Recommendation Report for Planning Permission for Works or Extension to a Dwelling

REF NO: FP/233/21/HH

LOCATION: 17 Bala Crescent
Felpham
PO22 8LY

PROPOSAL: Single storey rear and side extension, loft conversion and 1 x rear dormer.

DRAWING TITLE
PROPOSED SIDE (WEST) ELEVATION

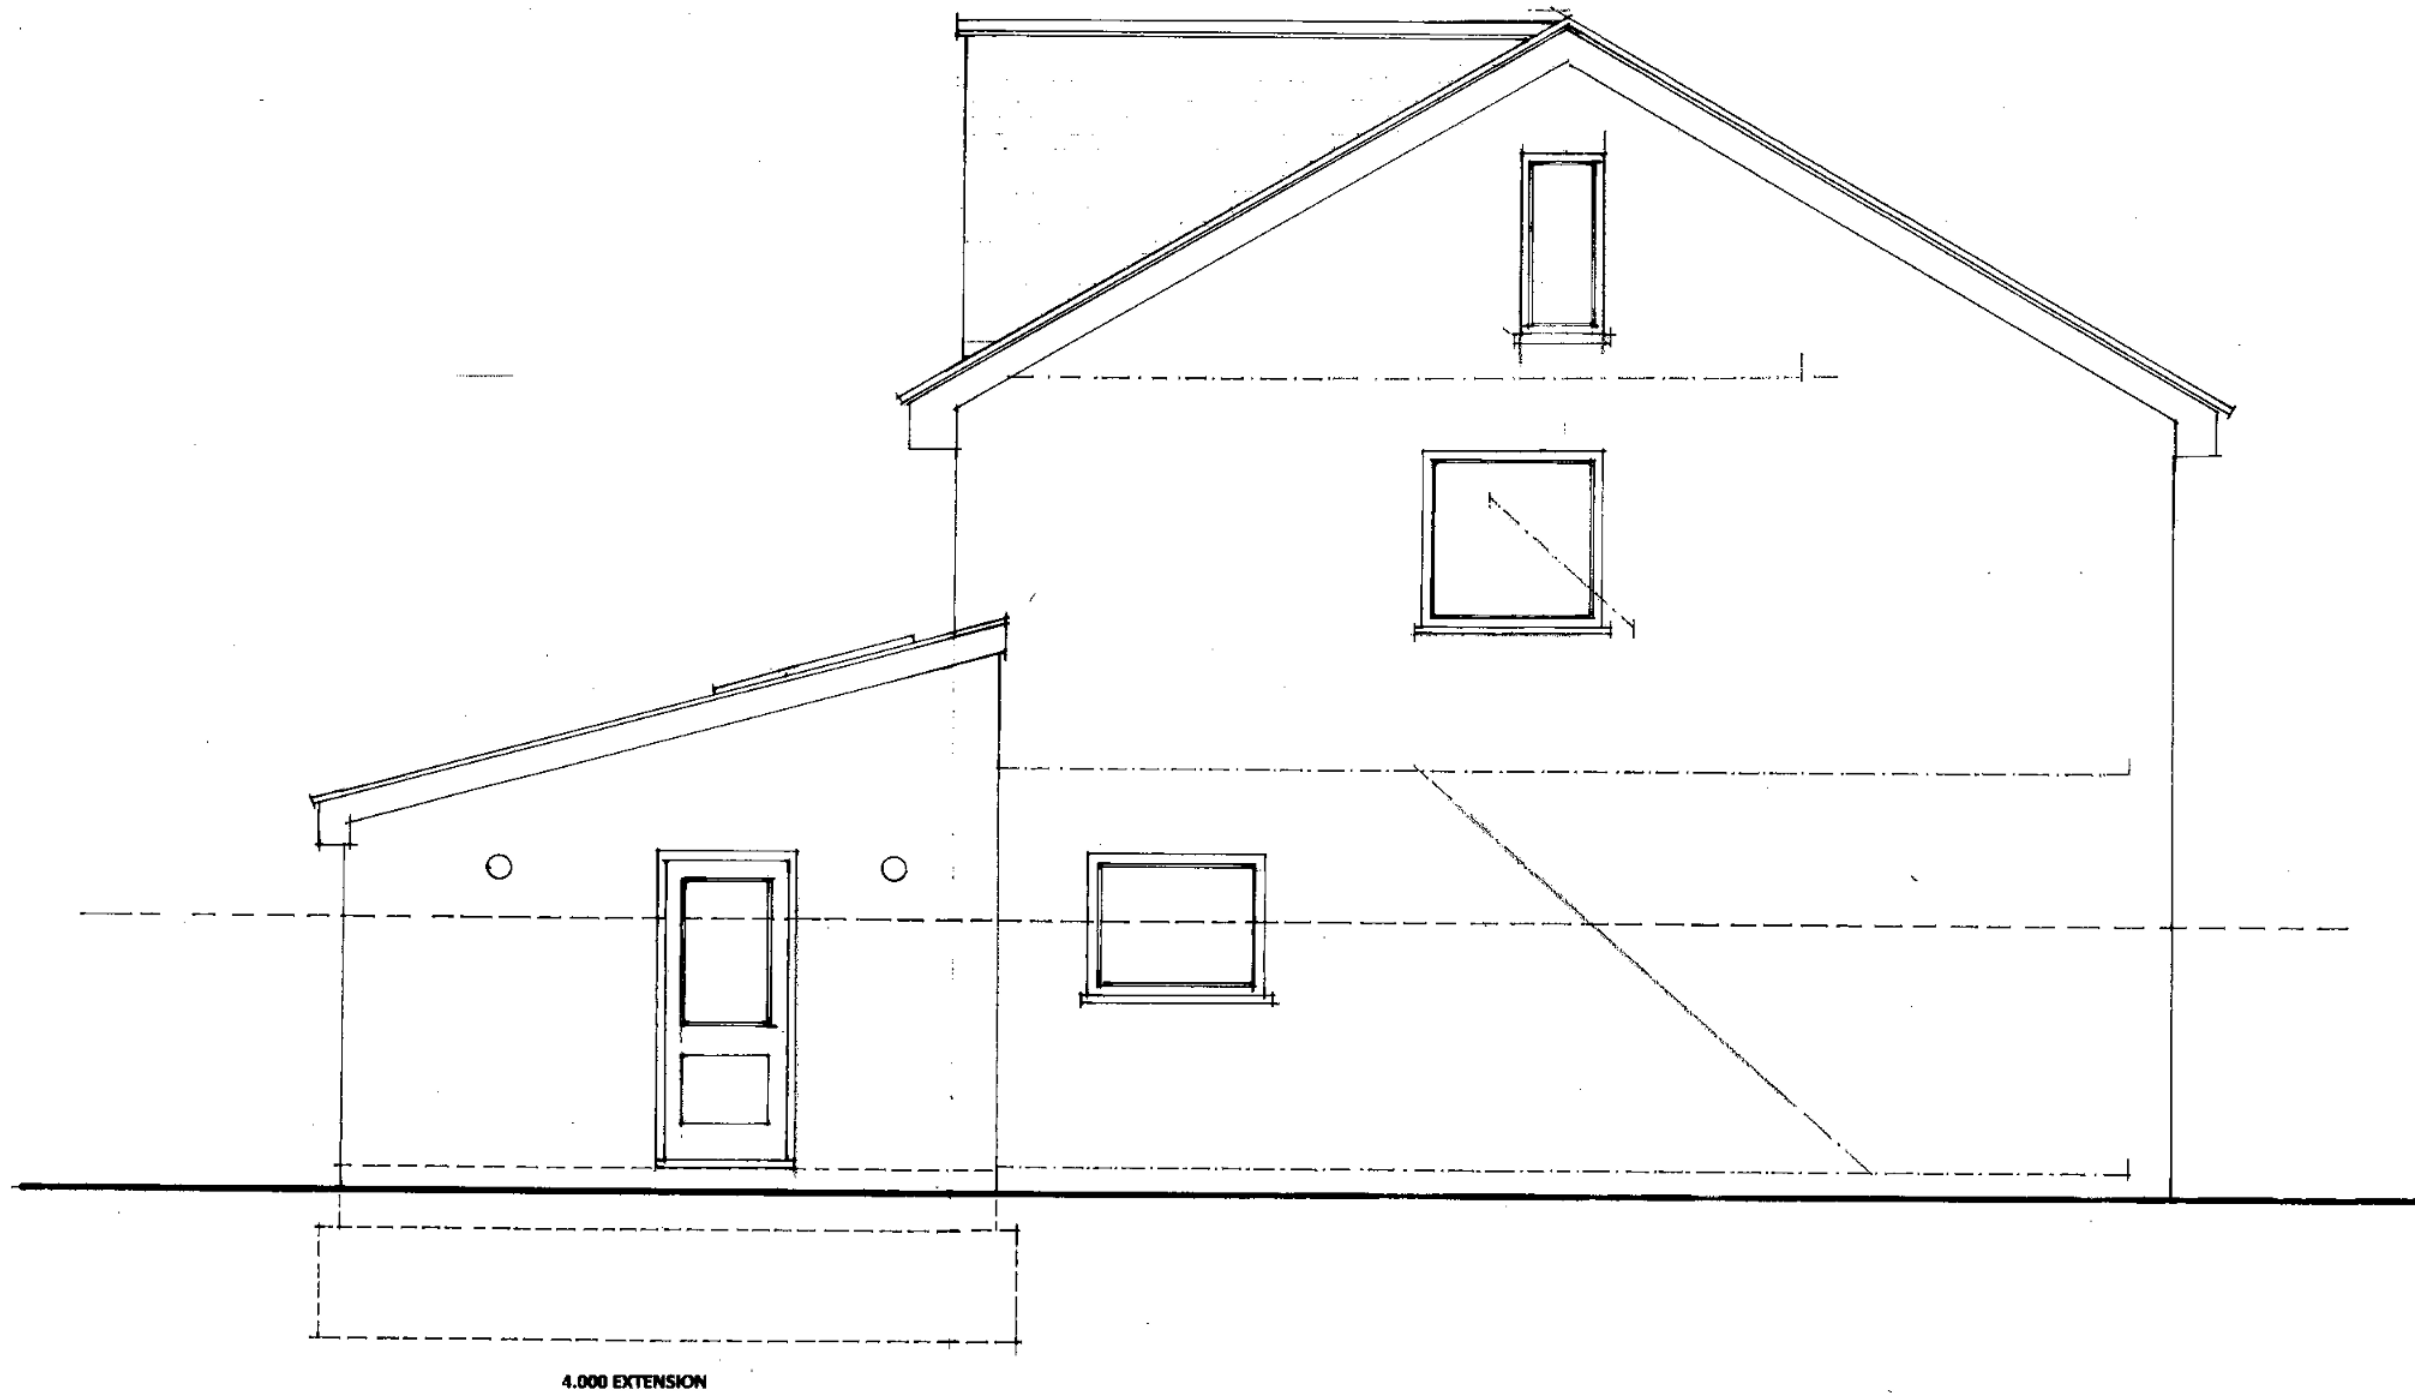
The proposal does extend beyond the property to the west however with some separation retained and boundary treatment in place, the impact are not considered significant.
